From: [Mike Podobnik](#)
To: [Jamey Ayling](#)
Cc: [CDS User](#)
Subject: Public Comments on Fowler Creek Guest Ranch, CU-23-00003
Date: Thursday, October 19, 2023 12:07:51 AM
Attachments: [Letter for the Residents of the Granite Creek Community dated 18 Oct 2023.pdf](#)

Re: Fowler Creek Guest Ranch, CU-23-00003

Letter for the Residents of the Granite Creek Community, Shawn M. Plichta, PE

EXHIBIT 16 - SITE PLAN - FOWLER CREEK GUEST RANCH

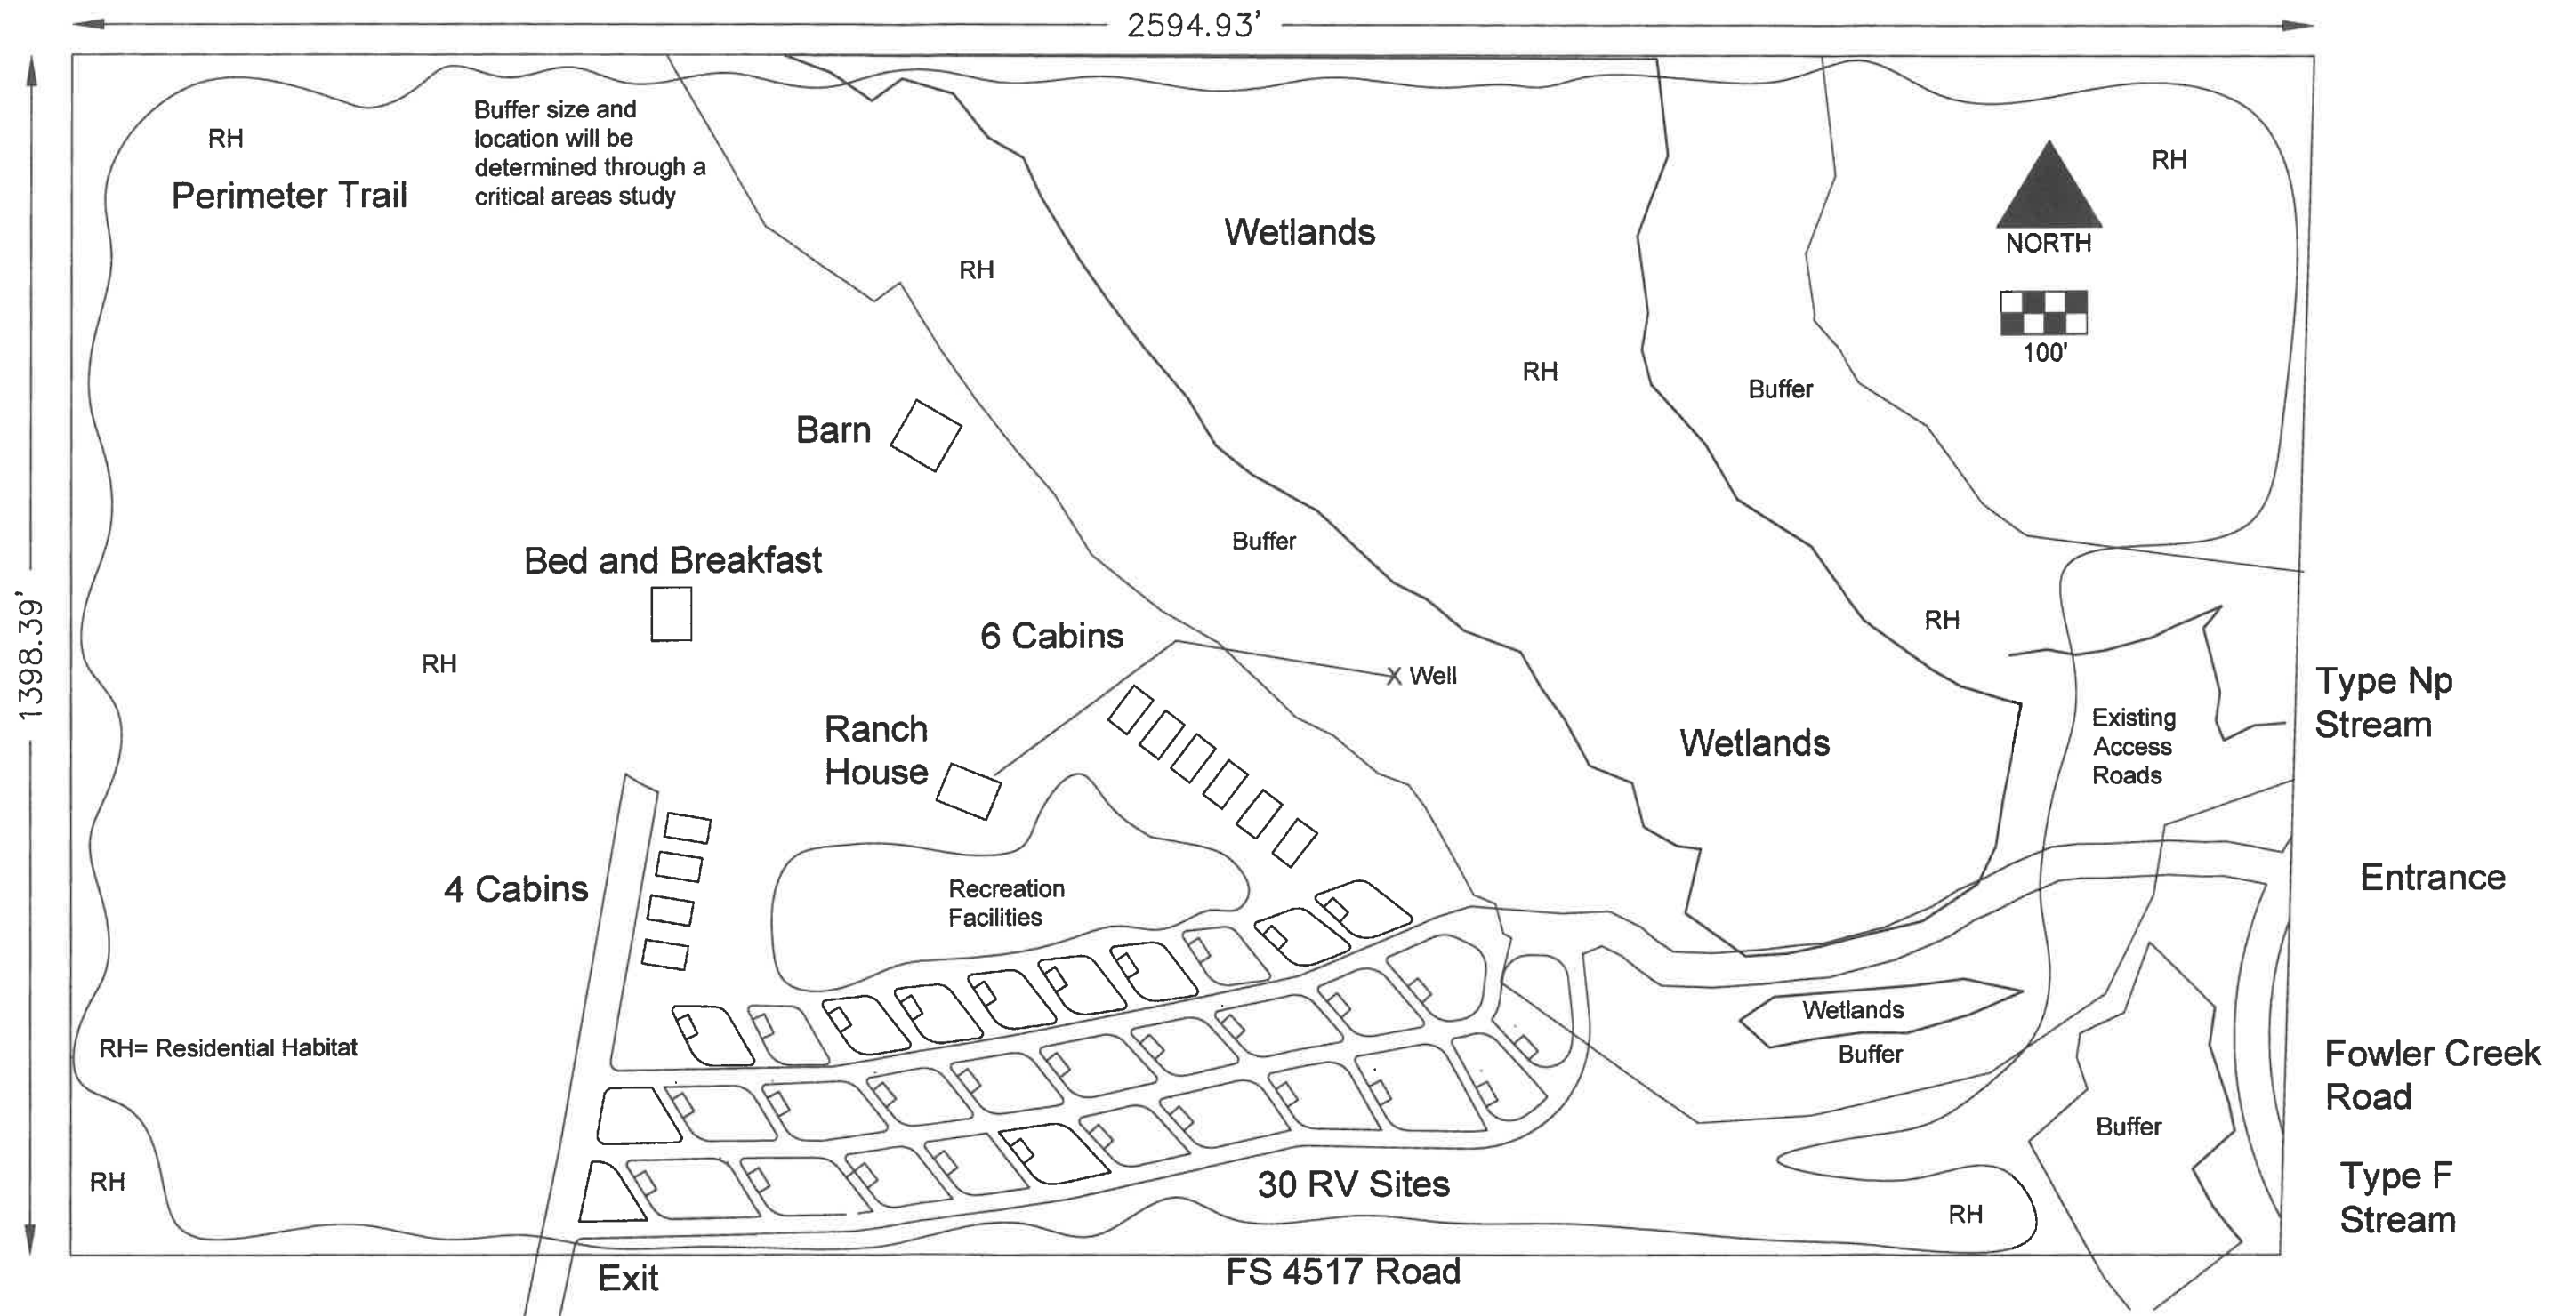
United States Forest Service (USFS) road 4517 is the single and readily available access into the Granite Creek community. On the Site Plan, the two points of access to the Guest Ranch are labeled "Exit" to USFS road 4517 and an "Entrance" from Fowler Creek Road. This access is currently unimproved and the "Exit" is the only means of egress from the Guest Ranch shown on the Site Plan.

My concern begins with the intersection of the "Exit" and USFS road 4517. In an emergency, such as a wildland wildfire, the traffic volumes proposed by the Guest Ranch combined with the residents and any vacation renters from approximately 120 lots in the Granite Creek community may exceed the capacity of this intersection and USFS road 4517. This existing USFS road may not have been designed and constructed to meet current standards for horizontal and vertical line of sight, stopping sight distance, turn radii for long wheel-base vehicles such as recreational vehicles, clear zone requirements, and roadway width for the traffic volumes and speed experienced in an evacuation scenario.

This situation is further exasperated with people, in a panicked state, evacuating the area sharing minimal roadway width with emergency responders trying to access the impacted area. These conditions create a higher probability for collisions and other accidents that may block USFS road 4517. Moreover, a mechanical breakdown of any vehicle may block the only access to the Granite Creek community and slow emergency response. The inability for people to evacuate and emergency responders to access the area increases the risk of significant loss of property and most importantly life.

In my opinion the proposed intersection and USFS road 4517 may not be adequate to provide safe egress for the Granite Creek community. Further engineering analysis should be completed for the proposed Site Plan in the permit application to ensure the combined traffic volumes for the Guest Ranch and Granite Creek community can egress the area both safely and expeditiously. Additional upgrades or improvements to the proposed access at the Guest Ranch as well as USFS road 4517 may be required to meet current standards in conformance with the Kittitas County Code.
